EL PASO COUNTY PLANNING AND COMMUNITY DEVELOPMENT DEPARTMENT

GRADING AND EROSION CONTROL PLAN CHECKLIST ROLLING HILLS RANCH FILING 2

Revised: July 2019

S:\OneDrive\Civil\Proj\Rolling Hills Filing 2\DWG\Plan Sheets\Improvement Plans\U4\RH2.dwg, 2/17/2021 8:48:15 AM

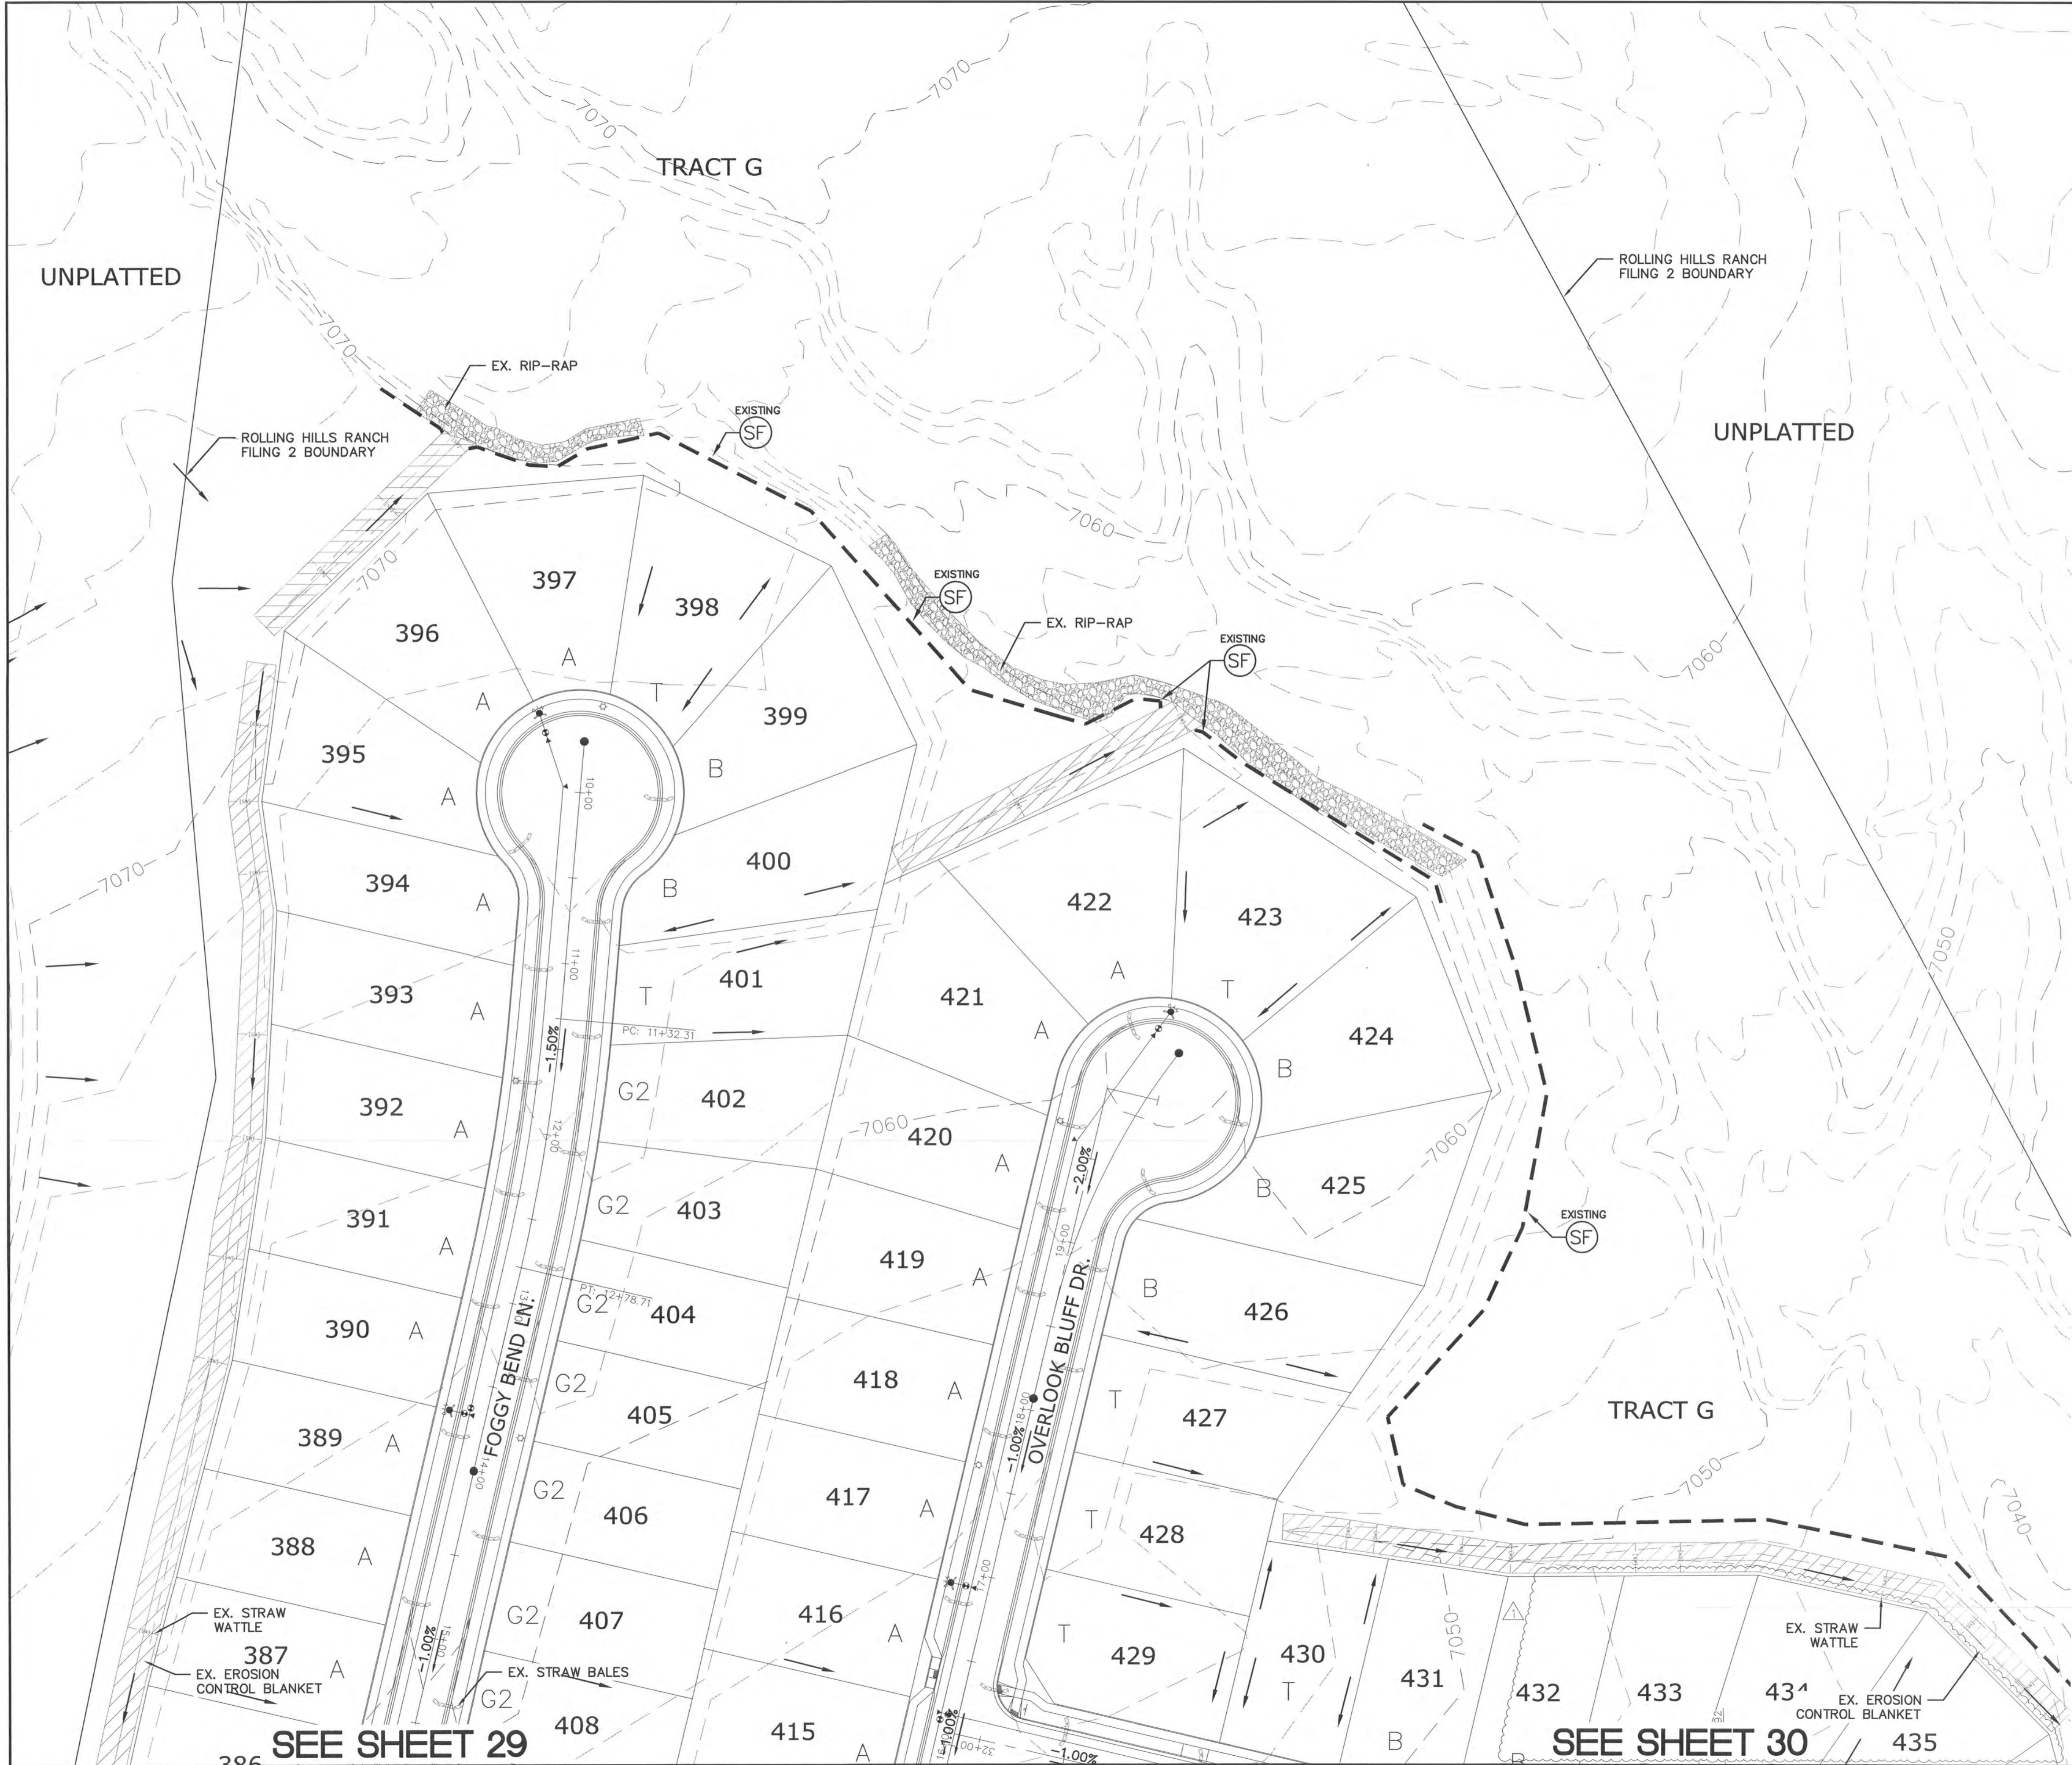
v	All proposed temporary construction control measures, structural and non-structural. Temporary construction control measures shall be identified by phase of implementation to include "initial," "interim," and "final" or shown on separate phased maps identifying each phase.	X	X
w	Vehicle tracking provided at all construction entrances/exits. Construction fencing, barricades, and/or signage provided at access points not to be used for construction.	X	✓
x	Temporary sediment ponds provided for disturbed drainage areas greater than 1 acre.	X	N/A
y	Dewatering operations to include locations of diversion, pump and discharge(s) as anticipated at time of design.	n/a	N/A
z	All proposed temporary construction control measure details. Custom or other jurisdiction's details used must meet or exceed EPC standards.	X	✓
